From: Anita Gardner
Sent: 06 November 2014 10:42
To: [REDACTED]
Subject: RE: EG/50/14/PL

**Conversion of existing agricultural buildings to form 1 No. dwelling house (including feed and equestrian store), 1 No. holiday let and associated garaging.
Tars Farm, Church Lane, Barnham, West Sussex, PO22 0DB.**

Location & Block Plan As Proposed

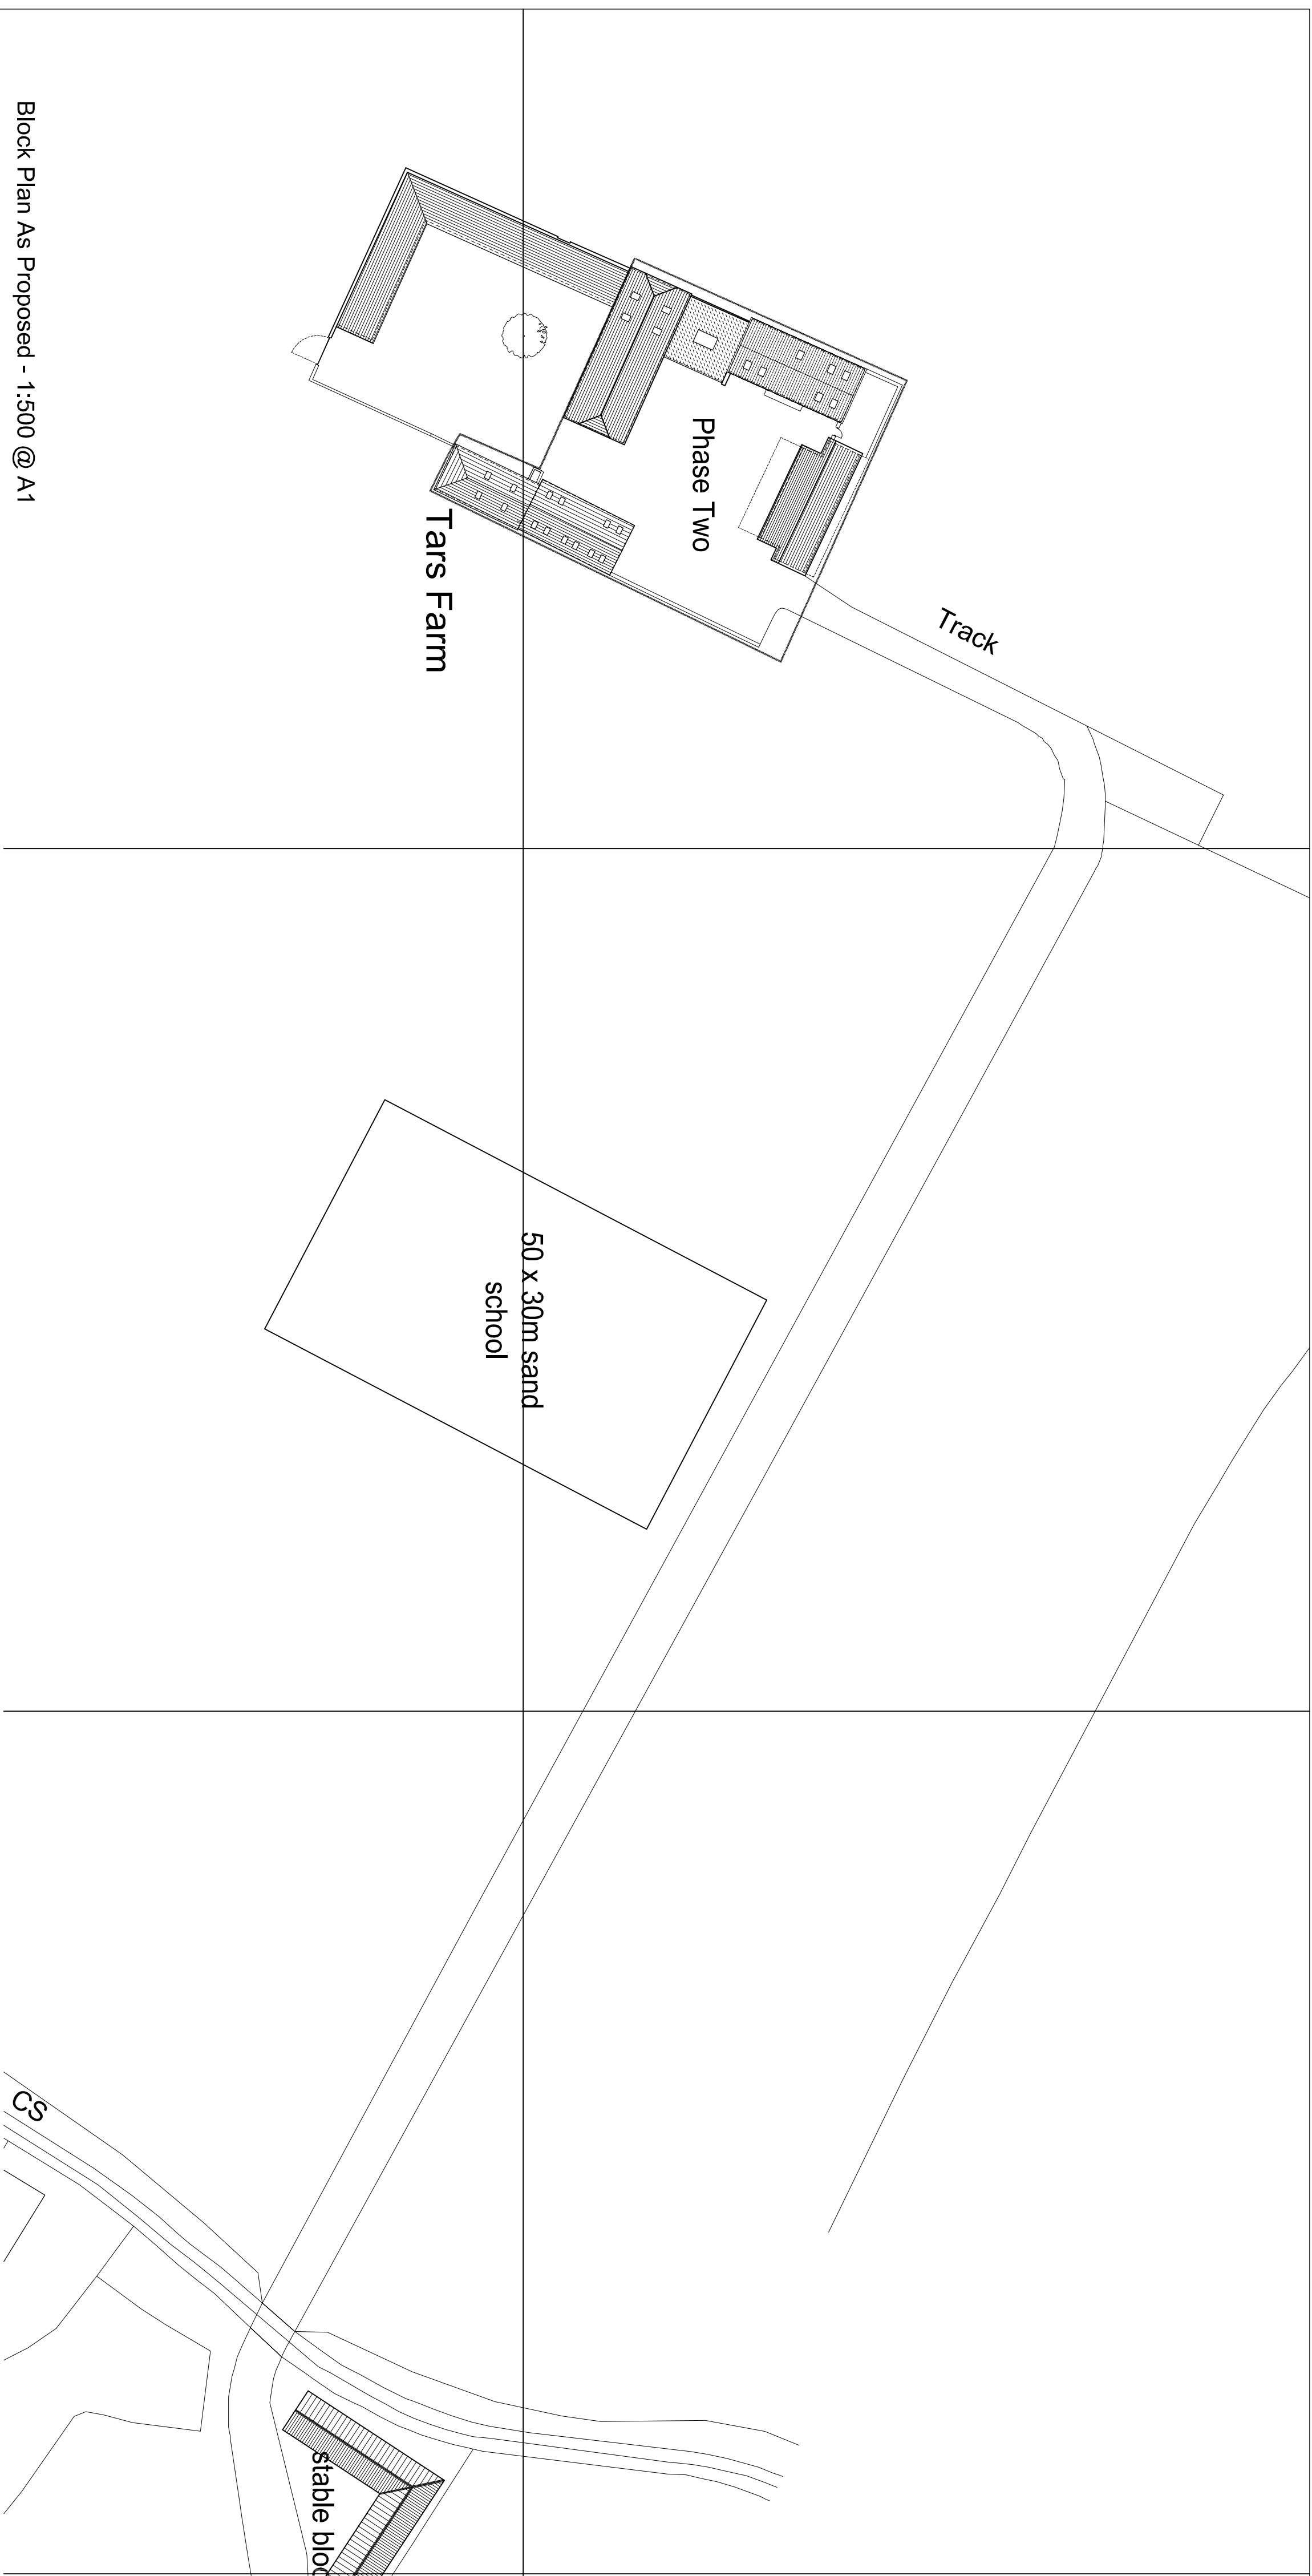
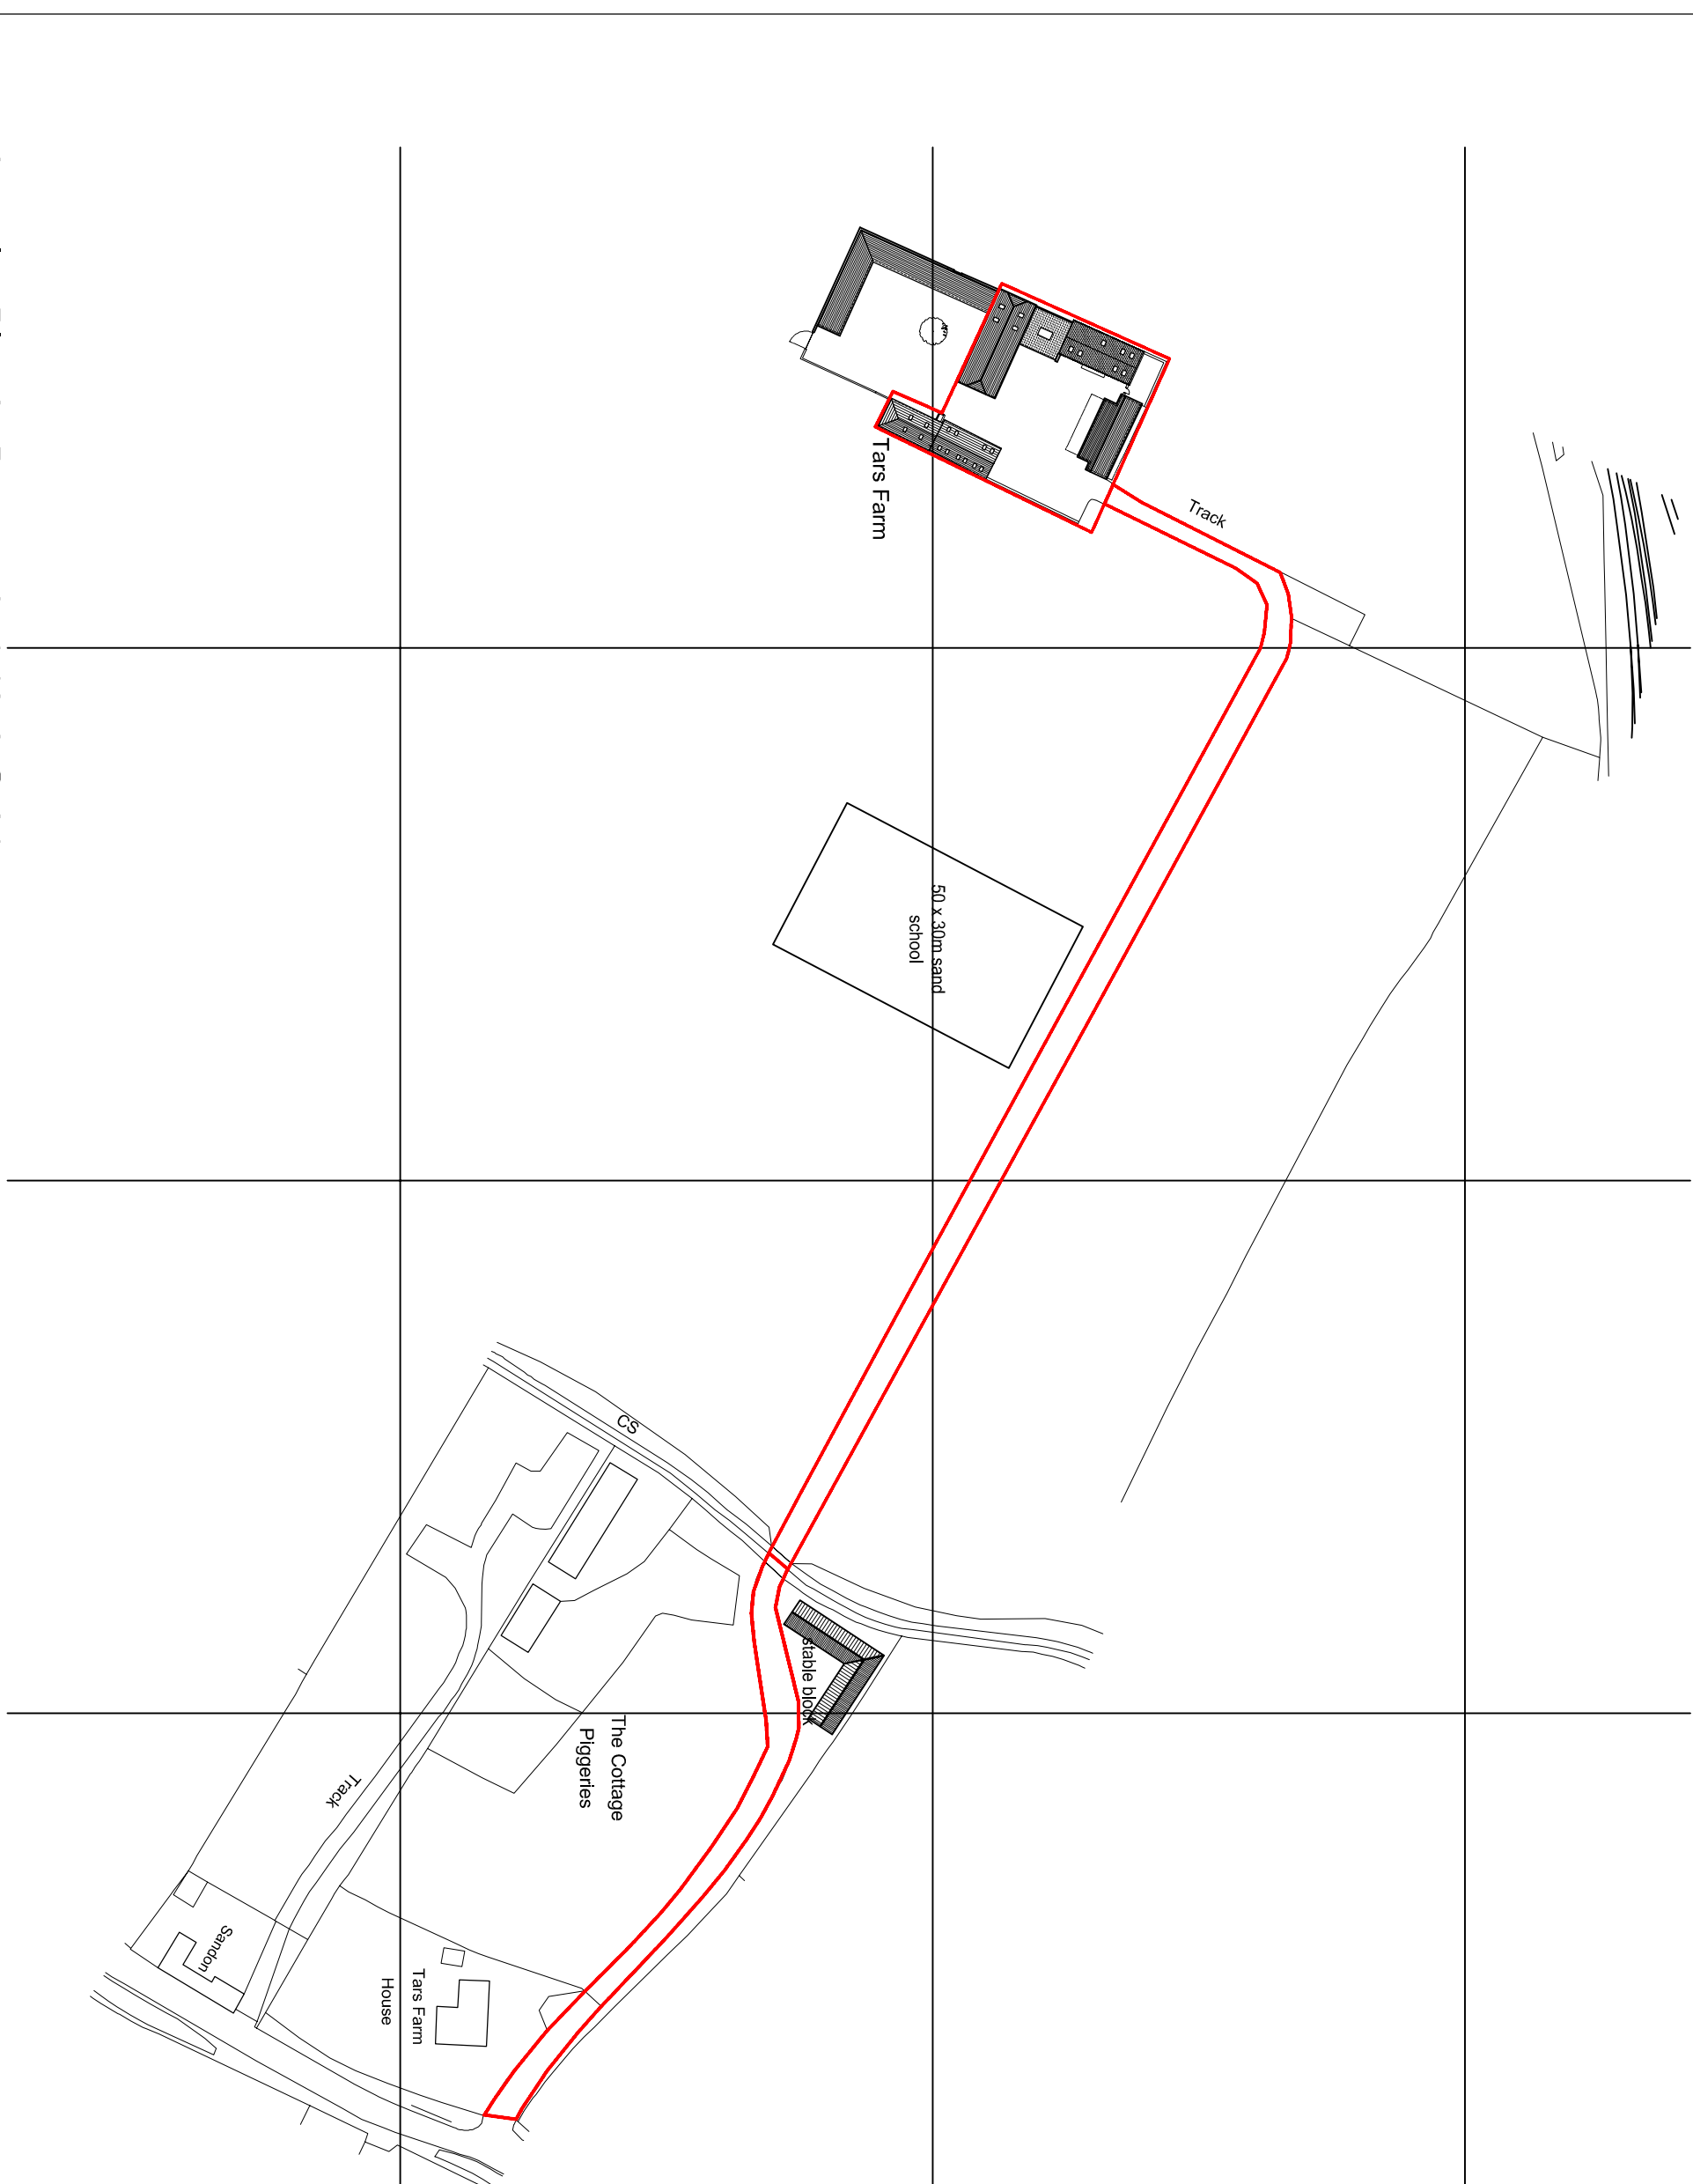
Need to ask for a further change to the block diagram. Because of the over-head electric pylons when it came to building the sand school we have had to re-orientate it. As such the planners are asking for an updated block plan for the barns to reflect the new sand school. Would it be possible to amend in line with the ppt diagram attached, although I am sure you have seen the school from the train !

The access has been actually shown to a ditch and not out onto the road.

Please extend the red edge to include the access out onto Church Lane on the Location Plan.
